Appeal Decision

Appeal Ref: APP/R5510/W/24/3340636

Flat 6, 18 Frithwood Avenue, Northwood, HA6 3LX

- The appeal is made under section 78 of the Town and Country Planning Act 1990 (as amended) against a refusal to grant planning permission.
- The appeal is made by Mr Curtis Komla Lebne against the decision of the Council of the London Borough of Hillingdon.
- The application Ref is 74383/APP/2023/2932.
- The development proposed is rear ground floor extension and rear roof dormer extension.

Existing and Proposed Plans

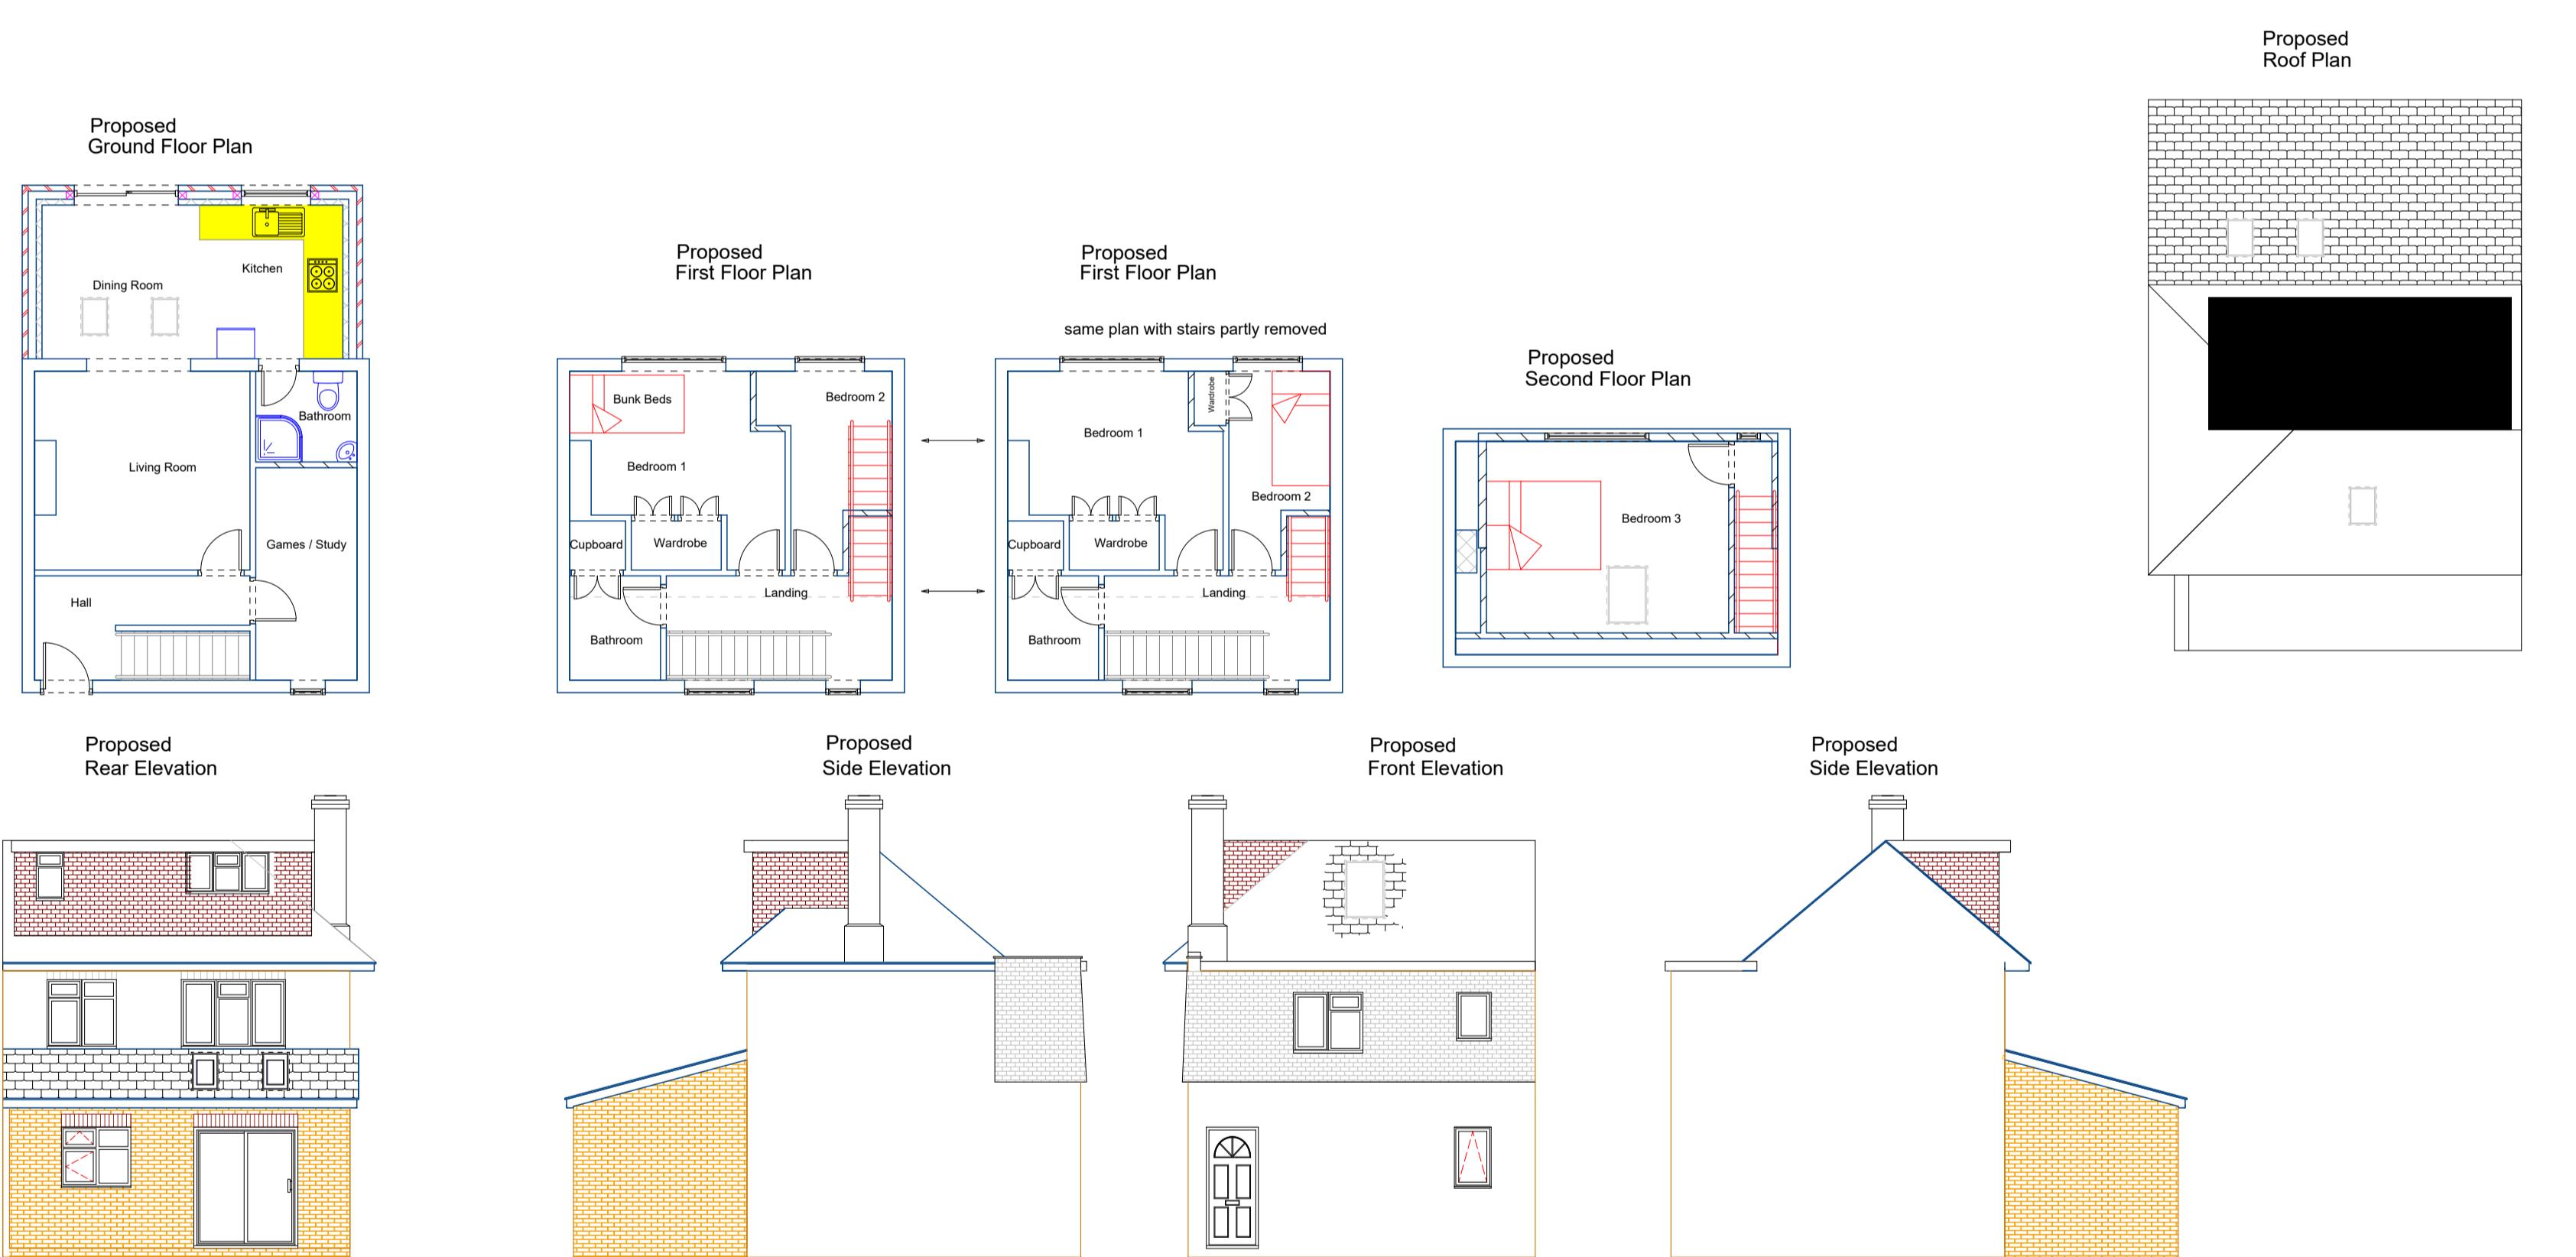
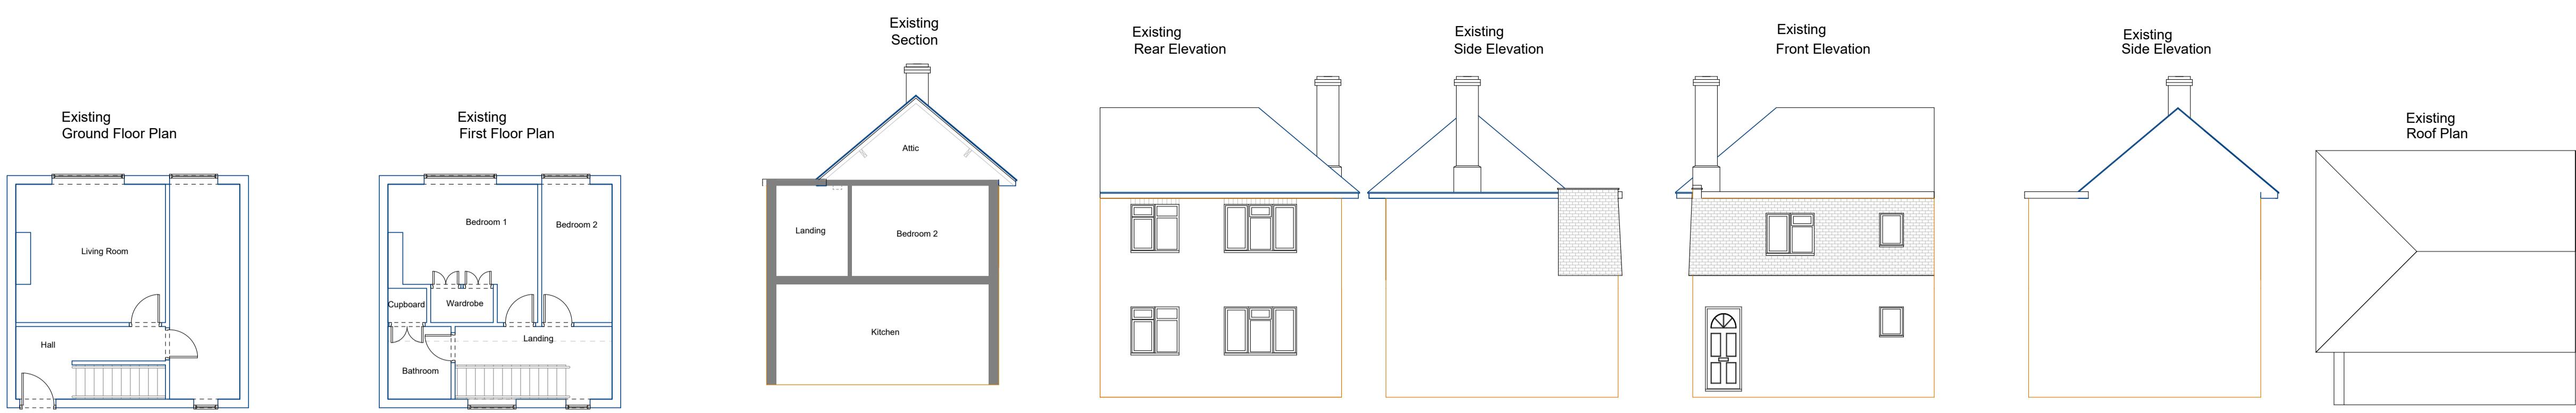
7. The proposed rear single storey extension would span the full width of Flat 6, covering up a large proportion of its rear elevation and would sit just below the first floor windows. Due to its height and bulk, the extension would be a dominant and unsympathetic addition to the building.

8. The proposed rear dormer roof extension would cover the majority of the existing rear roof over Flat 6. While it would sit up from the eaves, the dormer would be at the same height as the ridge of the existing roof over Flat 6 and span the majority of its width. The additional mass at roof level would result in a bulky and top-heavy appearance to the property which would not reflect the proportions of the existing building or others in the area. While the proposed dormer is at the rear, there are clear views of the rear roof from Bayhurst Drive. The scale and position of the rear dormer would also mean that it would be partly visible from the front elevation.

9. The rear elevation of No 18 has modest hipped dormers which are positioned well within the rear roof slope and harmonise with the existing building. The large box dormer proposed would dominate and obscure the existing hipped roof to Flat 6, substantially altering its form. This would be incongruent with the characteristics of the existing roof including the modest hipped dormers.

12. While the dormer would only represent less than two thirds of the existing roof span of the whole rear elevation and would be located below the existing ridge and above the eaves of the main building, it would nevertheless, be at the same height as the ridge of the roof to the ancillary wing and cover the majority of its roof slope. The scale and mass of the proposed roof extension would have a dominant and incongruent effect on Flat 6 and the host building as a whole.

13. Although the proposed alterations to the front of the building are modest in scale, part of the rear dormer extension would be visible from the front of the property and would look harmfully out of place.

20. The changes in ground level mean that No 18A is set on a higher level than the appeal site. Consequently, the boundary treatment between the appeal site and No 18A is higher than usual with wooden fencing atop a low brick wall. Nevertheless, the height of the proposed extension closest to No 19A would be considerably higher than the existing boundary fence. Furthermore, given its expanse across the full width of the ancillary wing and its position in relation to No 18A which is set forward of Flat 6, the proposal would diminish the outlook from the rear facing opening of No 18A, creating an increased sense of enclosure. This would also result in overshadowing to the property and thereby loss of light to it.
